From: Sue Howell
Sent: 03 May 2018 16:13
To: Planning.Responses
Cc: Simon Davis
Subject: RE: Planning Consultation on: AW/43/18/OUT

Comment from Greenspace

NOTIFICATION FROM ARUN DISTRICT COUNCIL
Town & Country Planning Act 1990 (as amended)
Town & country Planning (Development Management Procedure)
(England) Order 2015 - Article 5
Outline Consent
APPLICATION **AW/43/18/OUT**
NO:

Description of Works: Outline application with some matters reserved for the demolition of existing dwelling & erection of two pairs of semi-detached houses & associated works.

*proposed site plan*

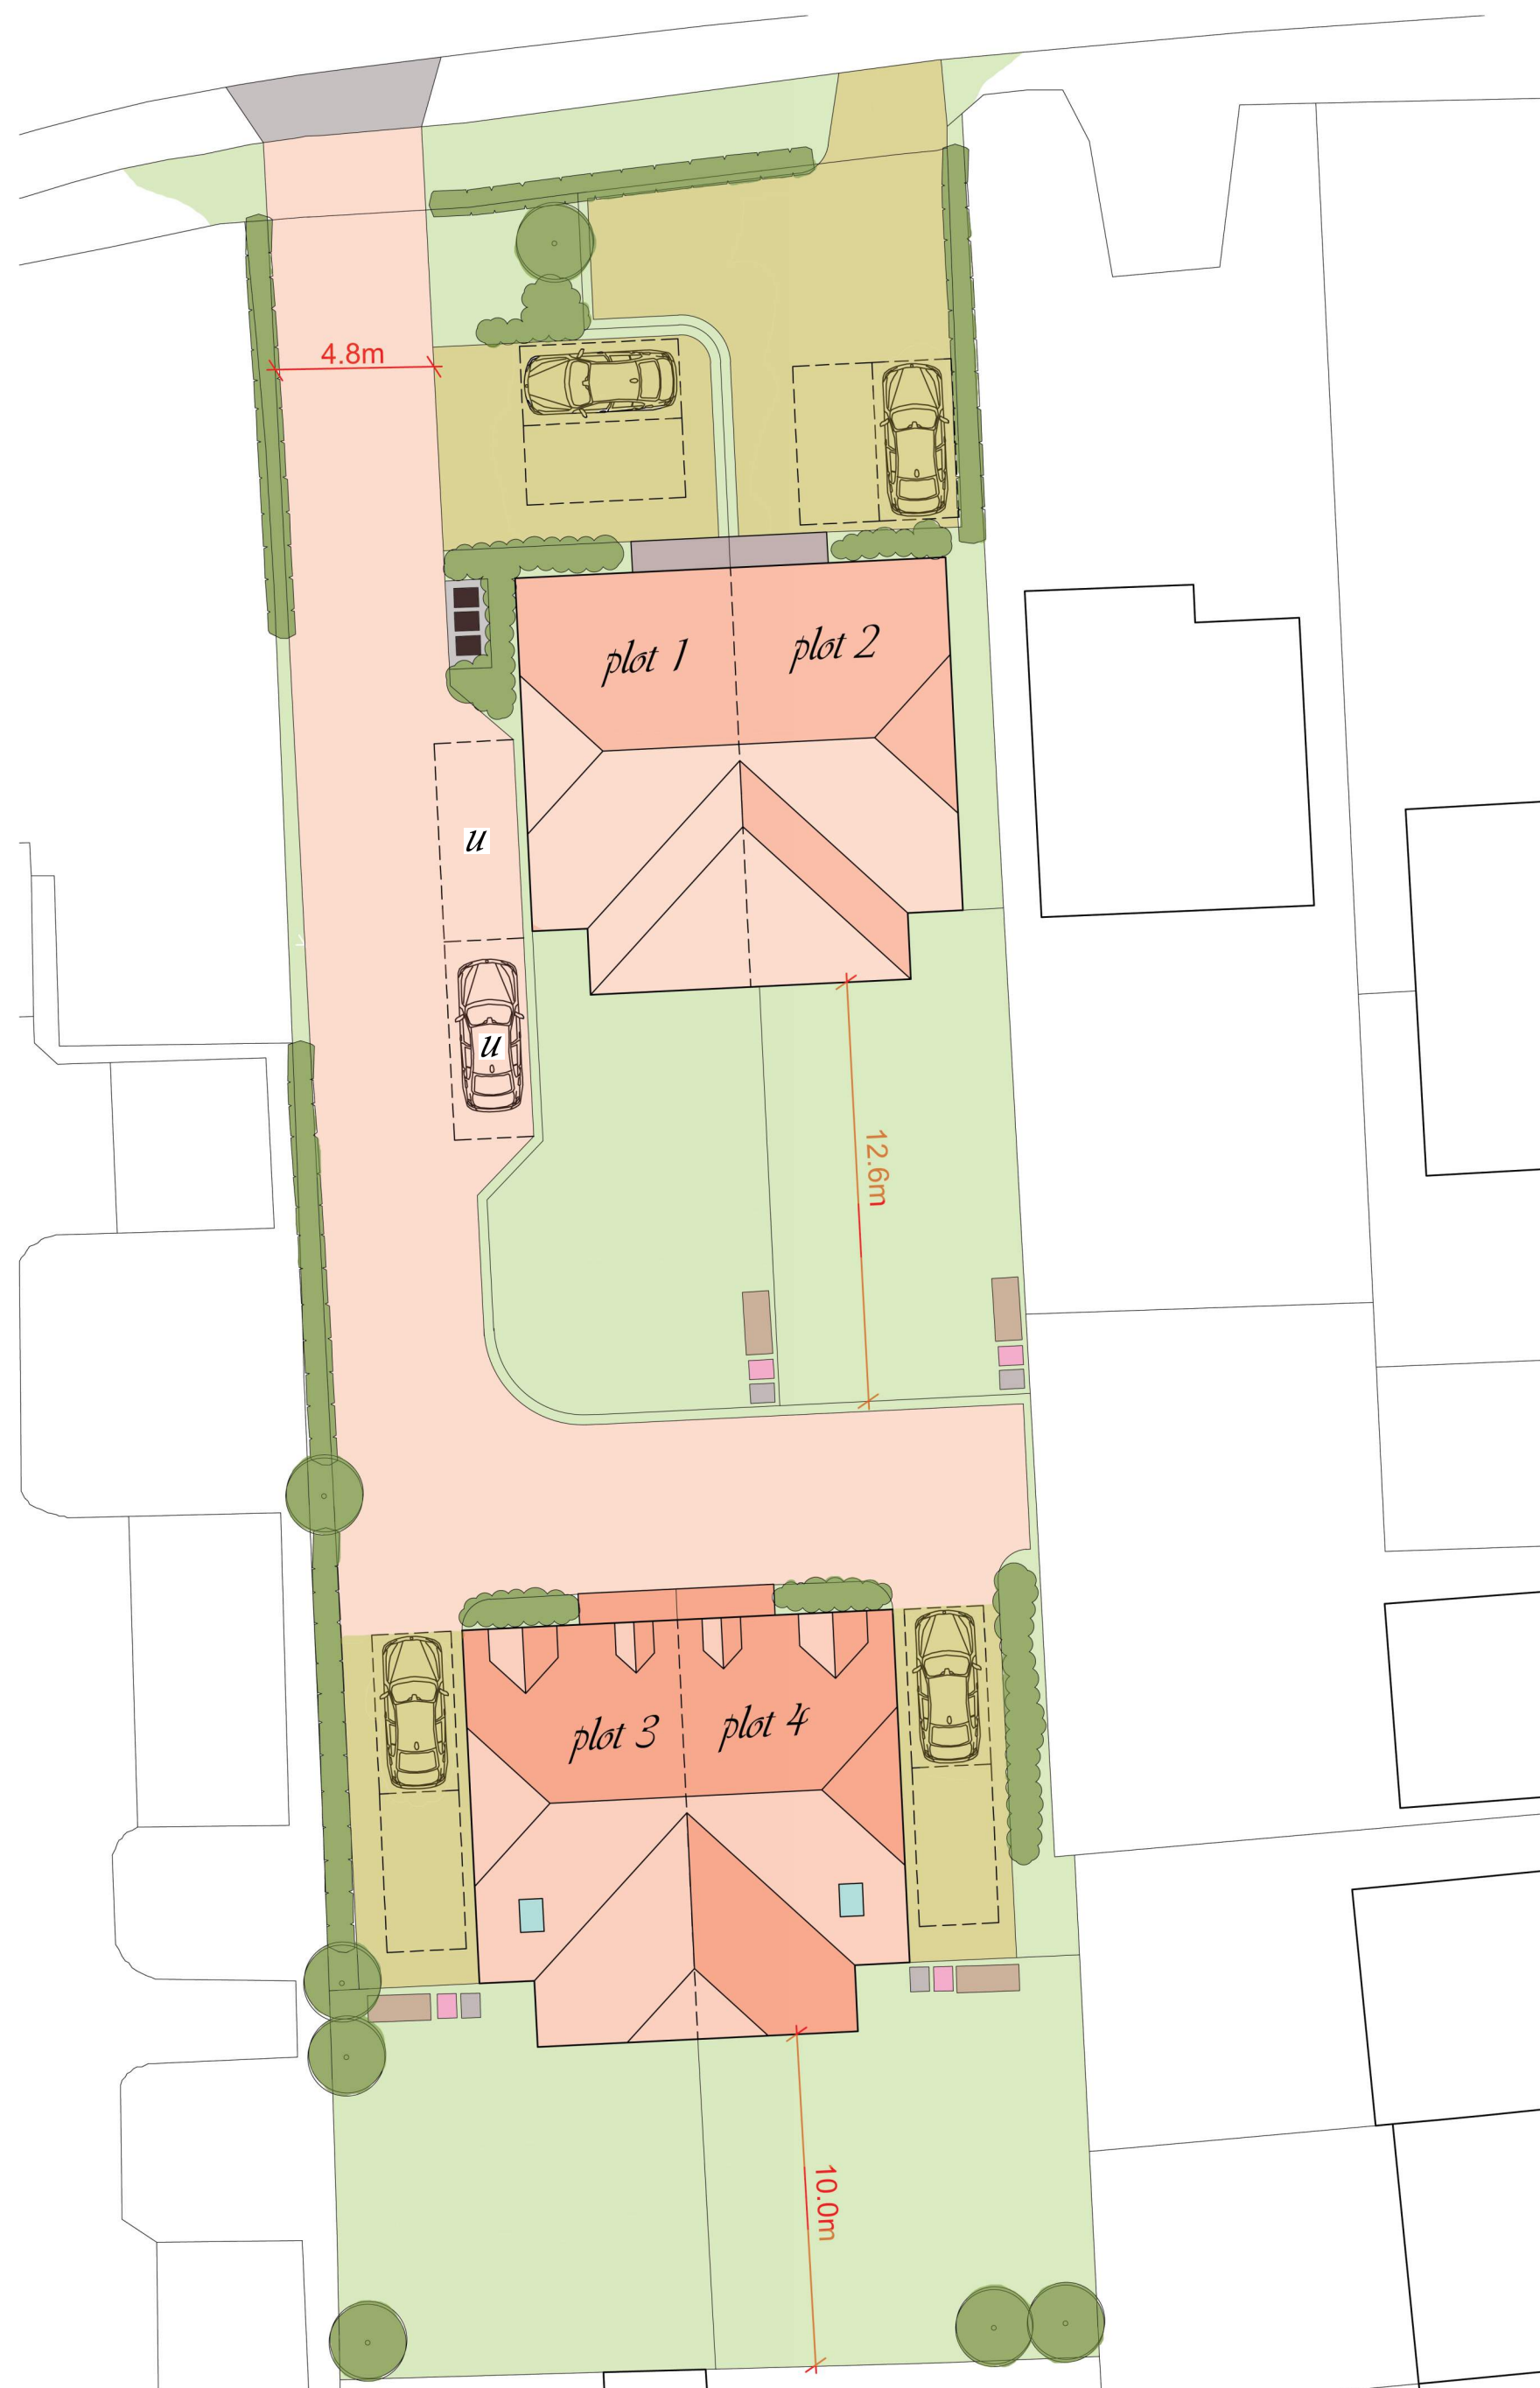
A detailed landscape scheme will need to be proposed that will maximise the biodiversity of the site, with the inclusion of mixed ornamental planting suitable for location, enhancing biodiversity and forming a variety of habitats. The landscape proposals will need to be shown in plan from detailing species choice, planting densities and size at time of planting. This will need to include mitigation planting for any proposed removed vegetation and possible additional planting to provide appropriate screening to adjacent properties.

Tree Constraints Plan
261 Aldwick Road, Bognor Regis

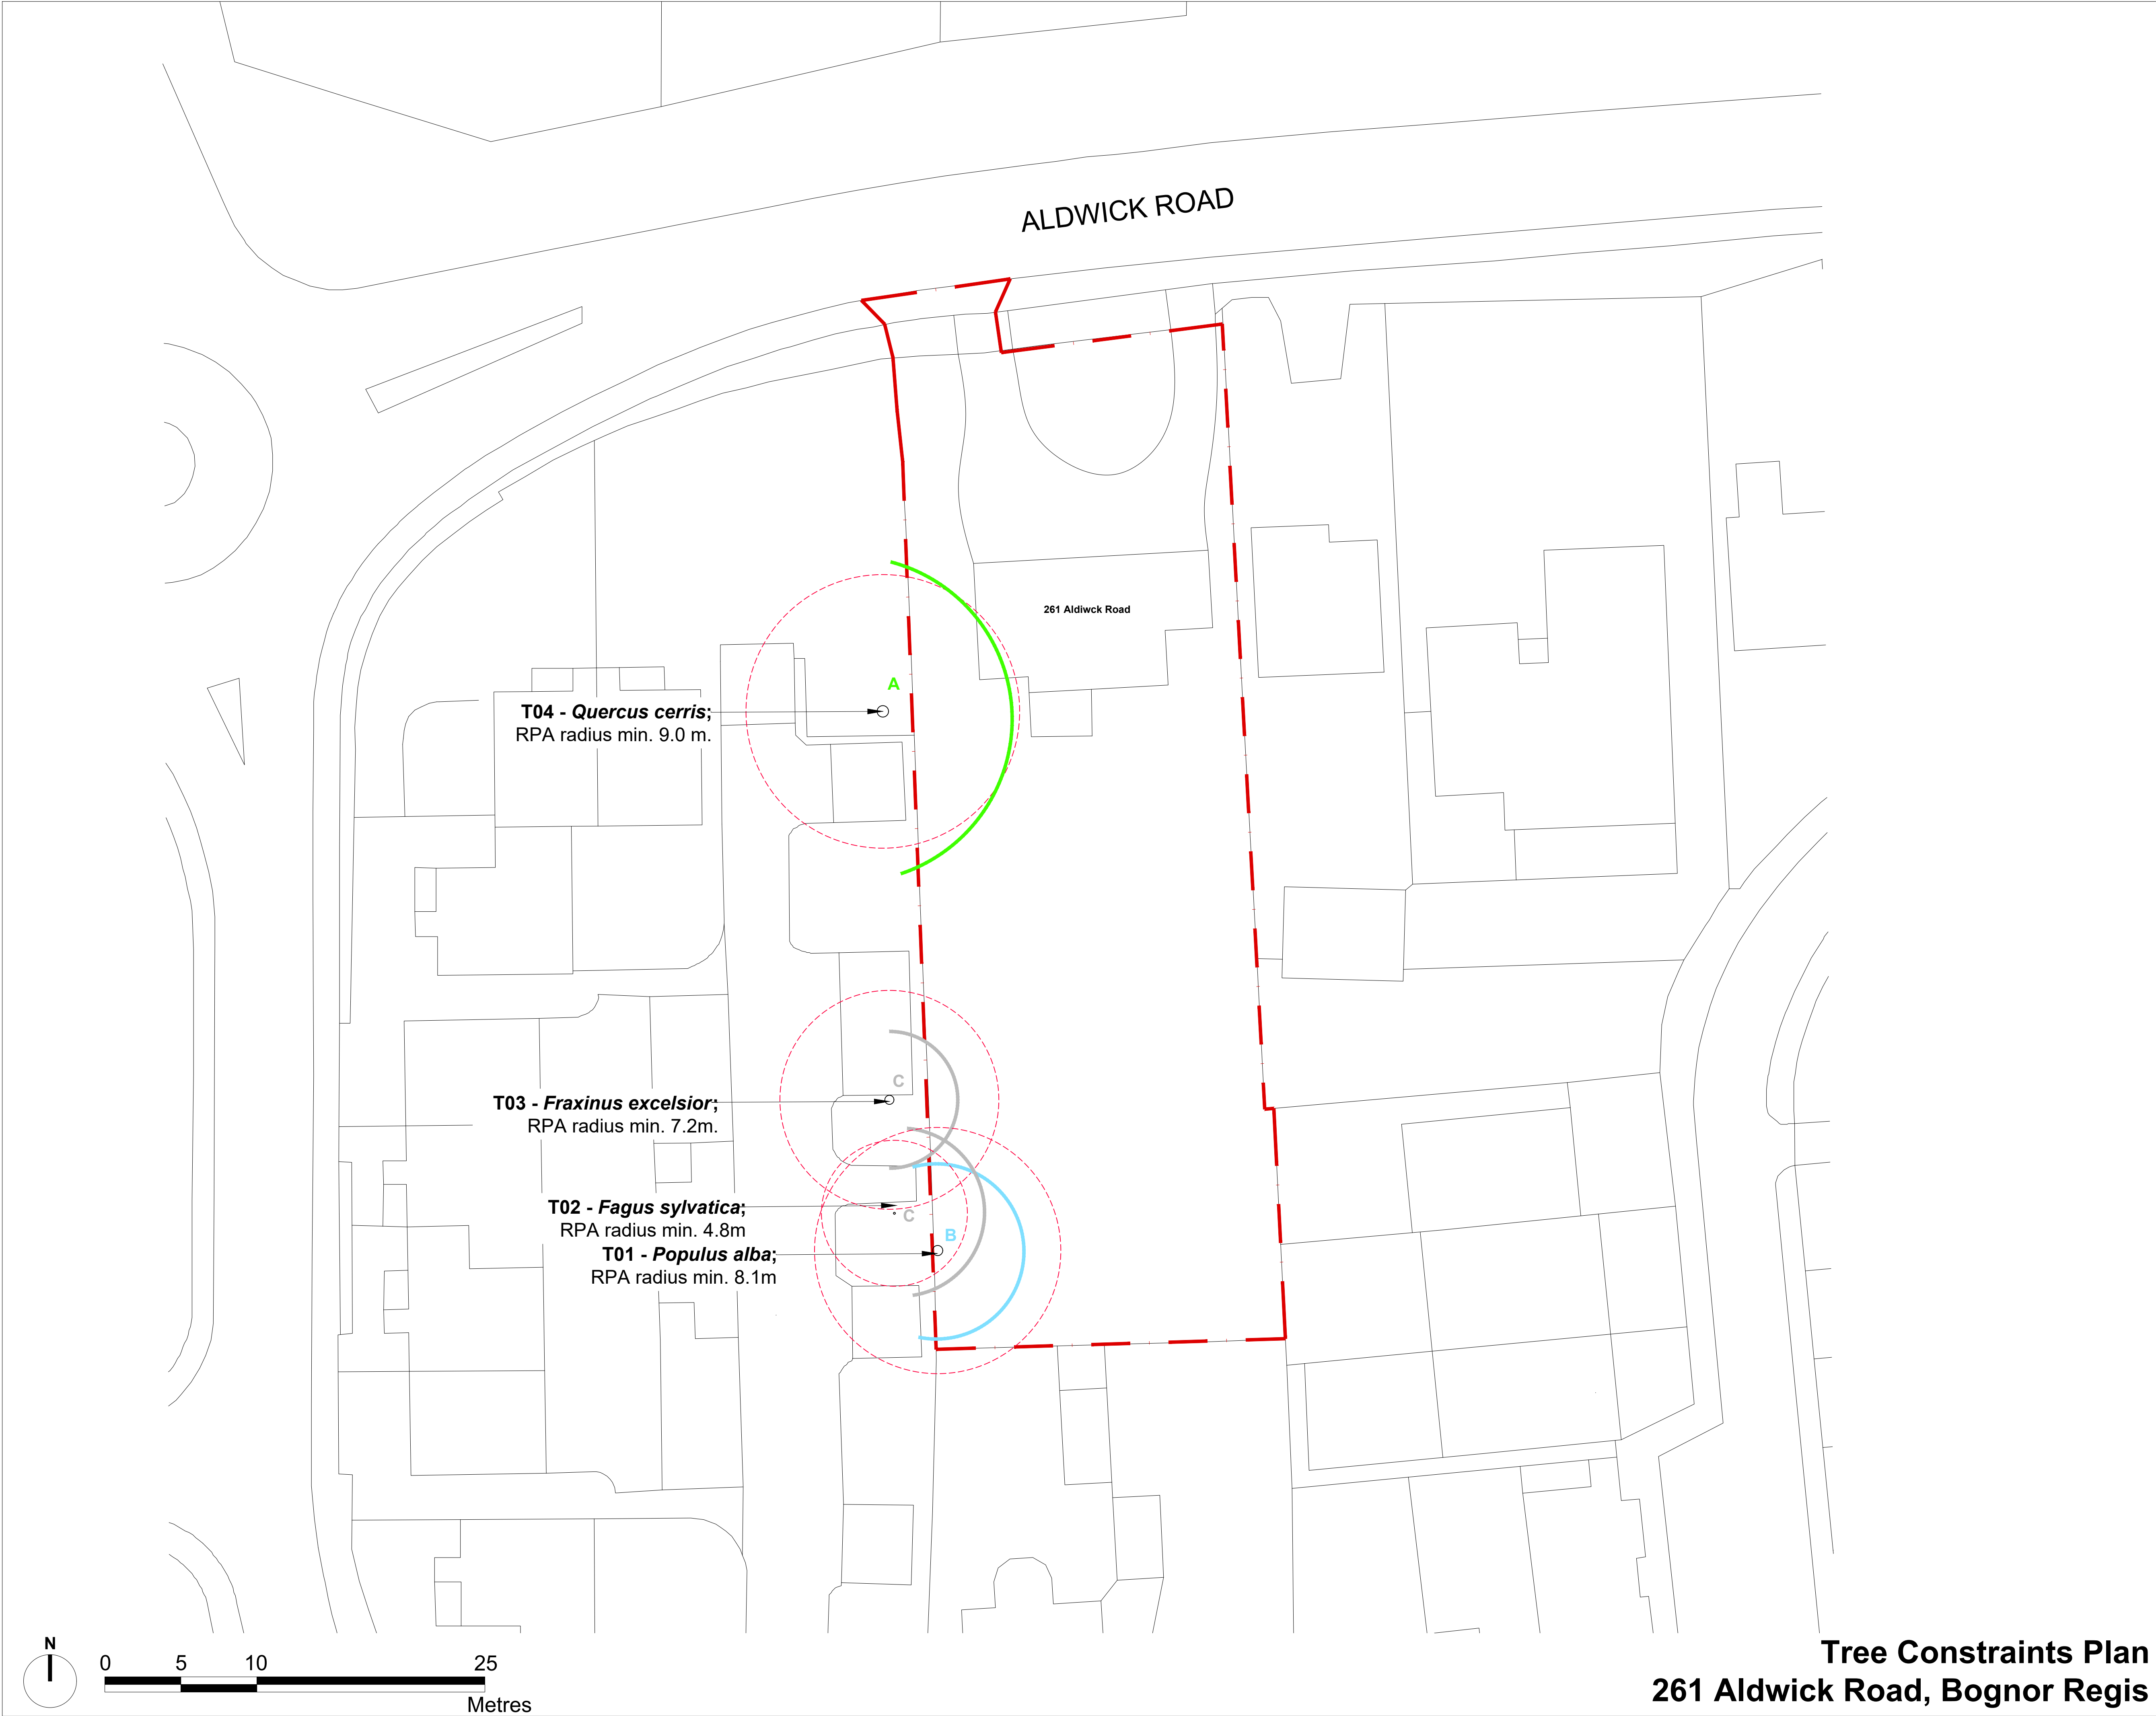
As this is a small development of only 4 dwellings there is no requirement for public open space or play provision. There are trees to the boundaries of this application site which should be considered within these proposals. Any proposed tree works to this site should be in consultation with agreed with Arun District Councils Tree Officer. The existing vegetation to boundaries is established, these areas need consideration, be protected and retained. Before construction a tree protection scheme must be in place for all retained trees including trees whose root protection areas fall within the construction zone from neighbouring properties. This should be in accordance with BS 5837:20012 ‘
